DEVELOPMENT REVIEW BOARD  
TRANSPORTATION DEVELOPMENT

DRB Project Number: 1000111  
Altura Complex

SUBJECT: Preliminary/ Final Plat

PLAT OF TRACT B1 AND B2 ALTURA COMPLEX WITHIN SECTION 11, TOWNSHIP 10 NORTH, RANGE 3 EAST, NEW MEXICO PRINCIPAL MERIDIAN CITY OF ALBUQUERQUE BERNALILLO COUNTY, NEW MEXICO JULY 2018

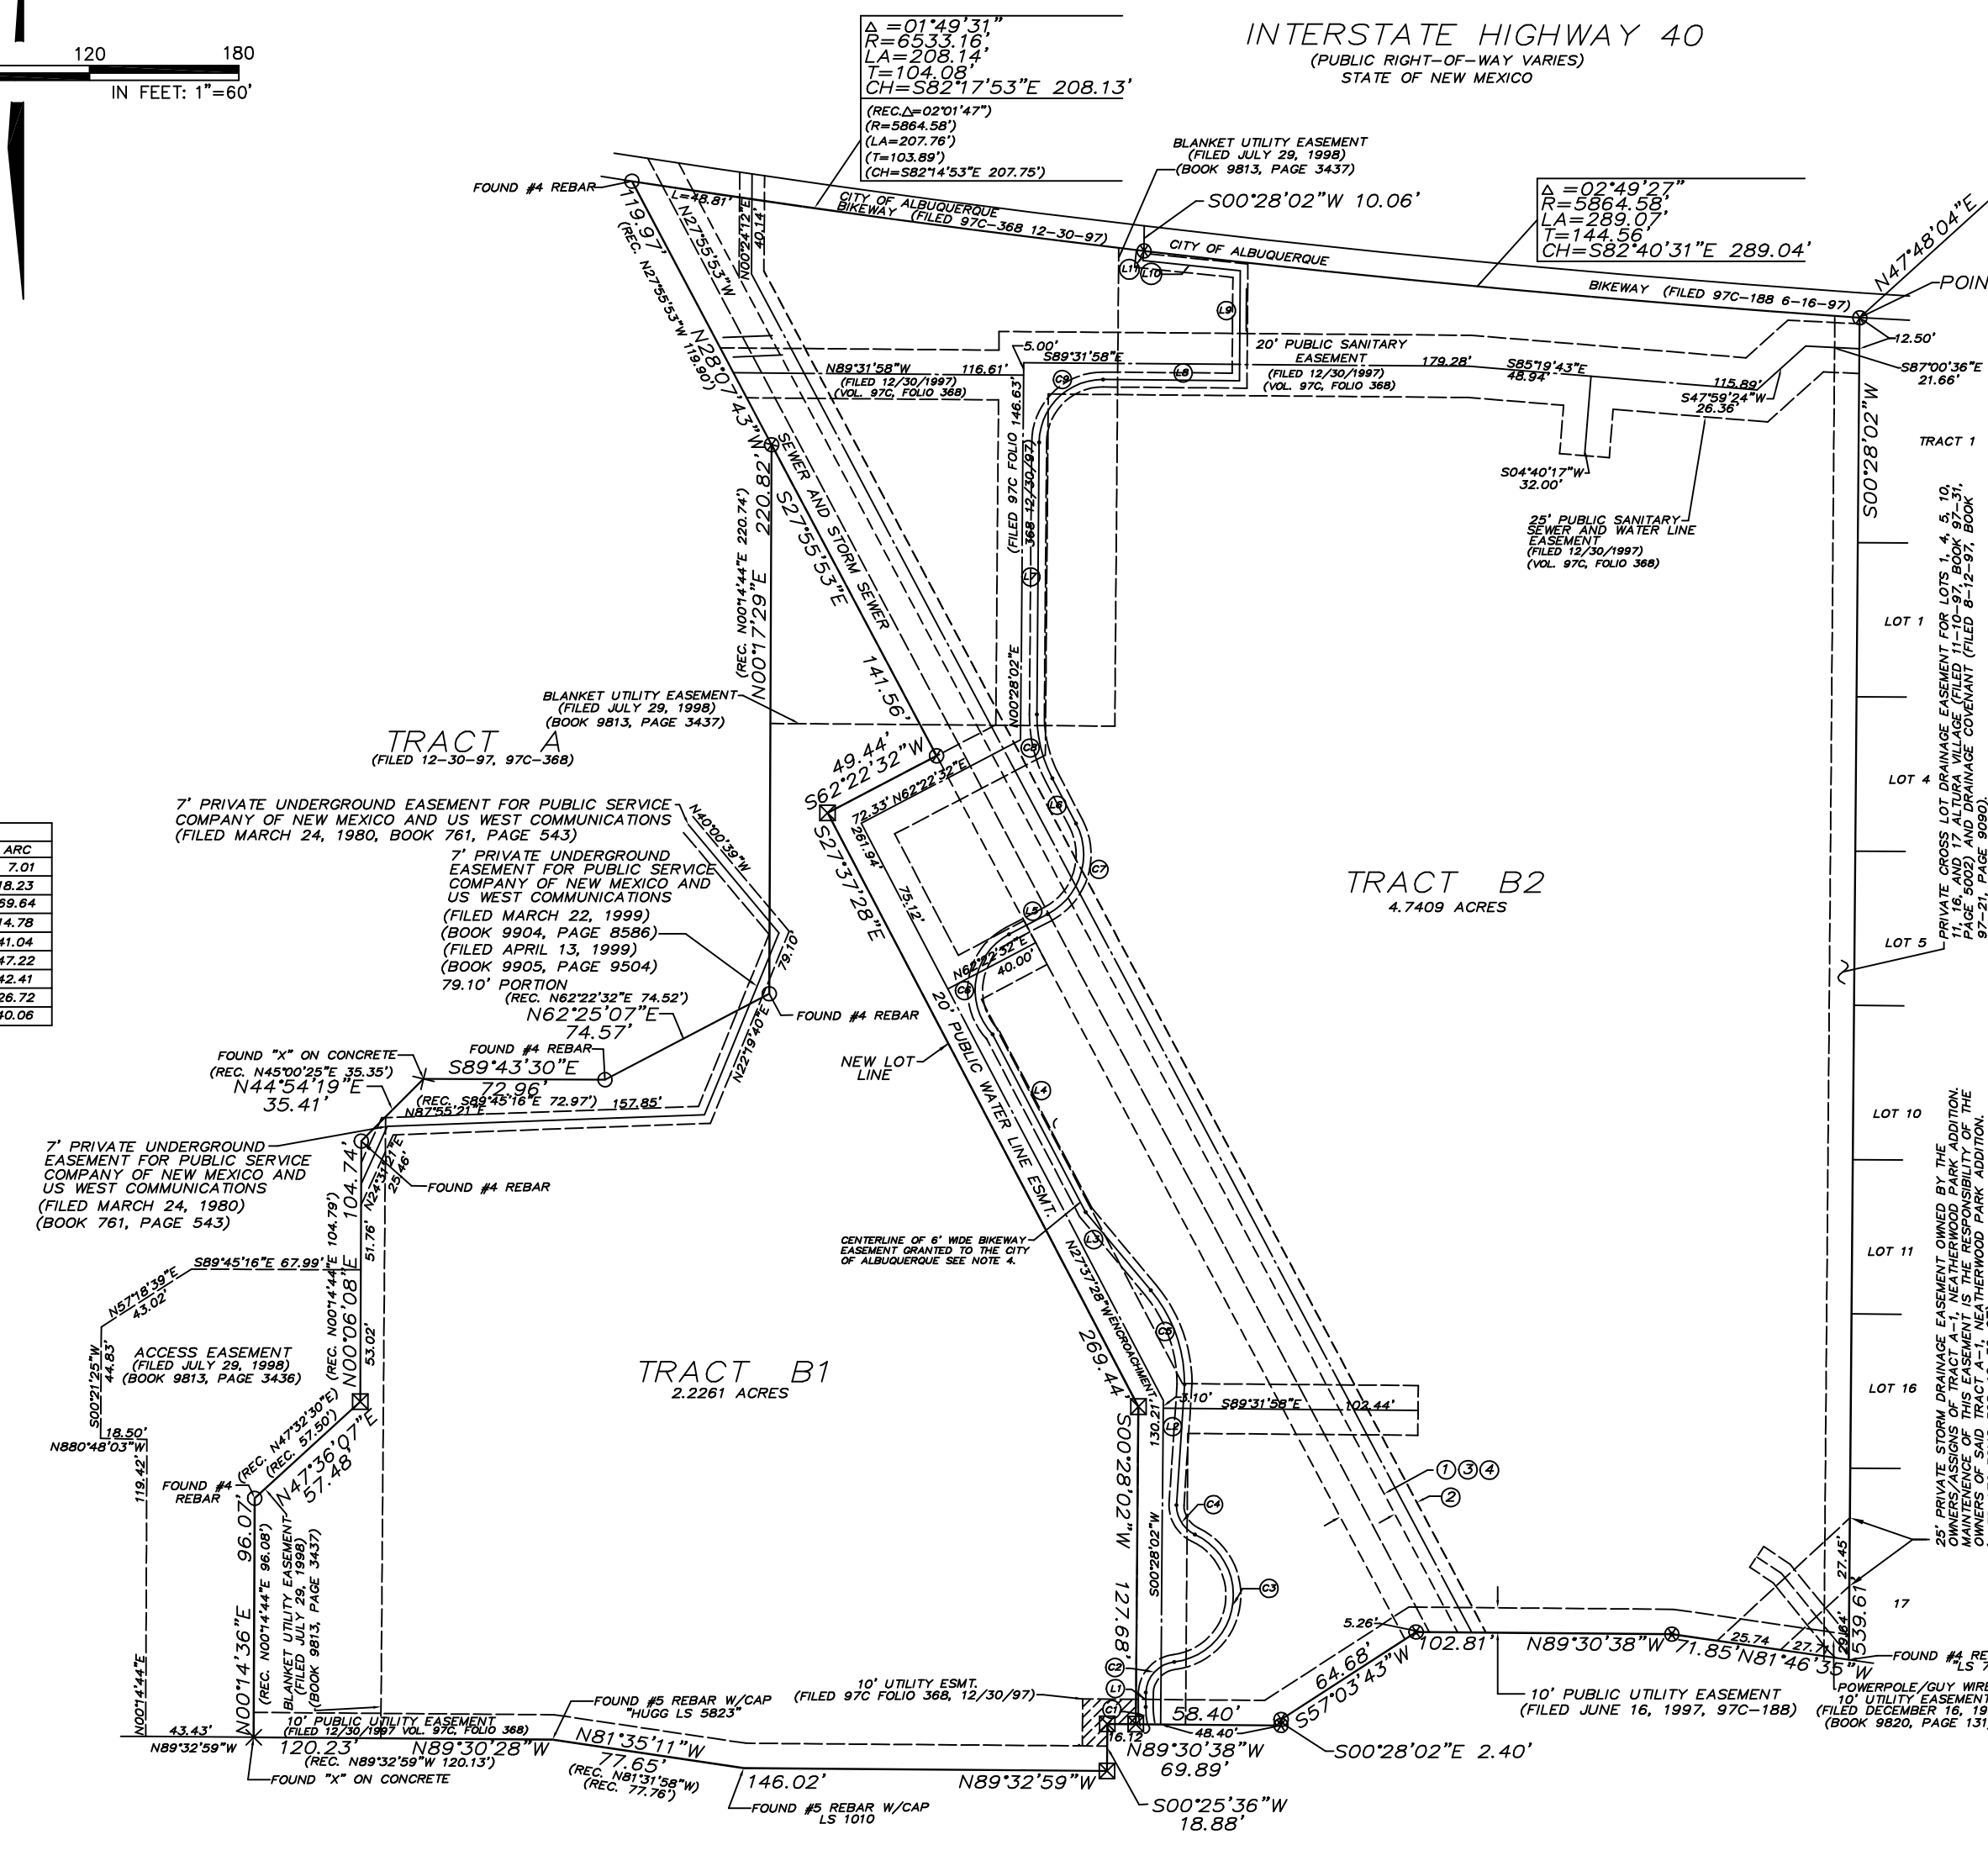
1. Provide a shared access easement between Lots B1 and B2.
2. For final plat, any access easements need to be shown with all beneficiaries and maintenance responsibilities listed.

↳ owner working on agreement
